JUDGE ORR RANCHETTES

PRELIMINARY PLAN

PCD FILE NO: SP-17-011

Markup Summary

JUDGE ORR
RANCHETTES
PRELIMINARY PLAN

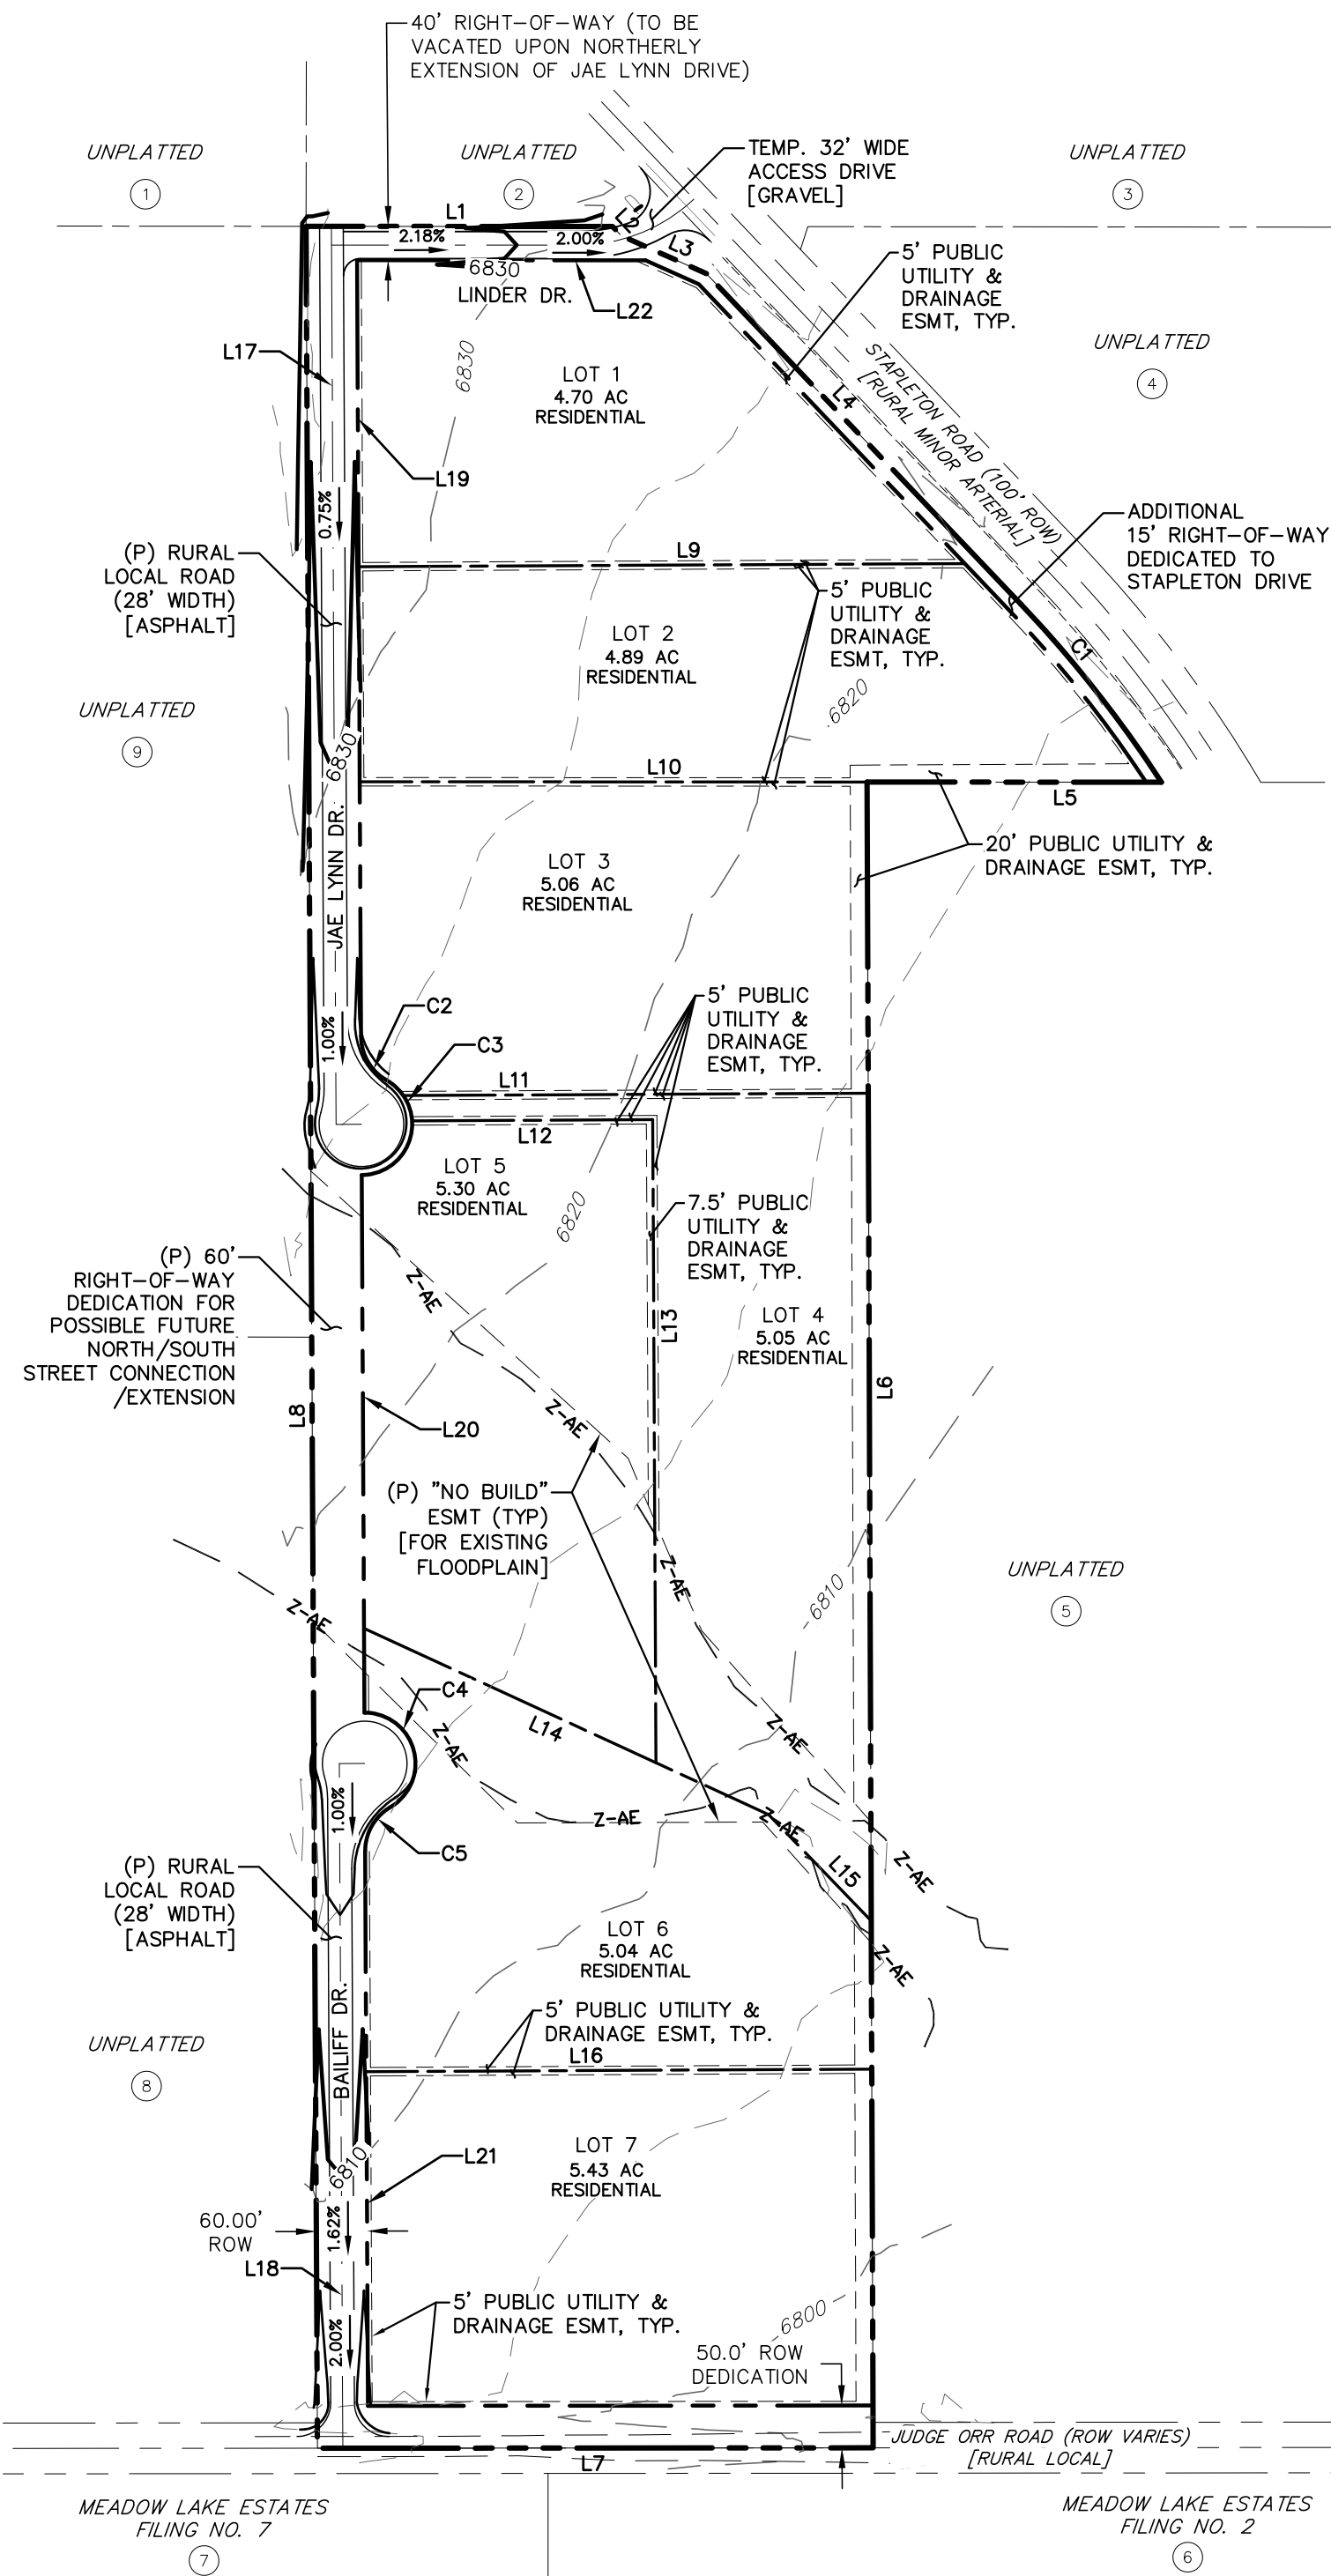
update the label to match the plat

double property line

Add anticipated water, sanitation, gas, electric.

Add utility easements (existing/proposed).

other arrow is missing

add a note indicating the purpose of this area and the double cul de sacs.
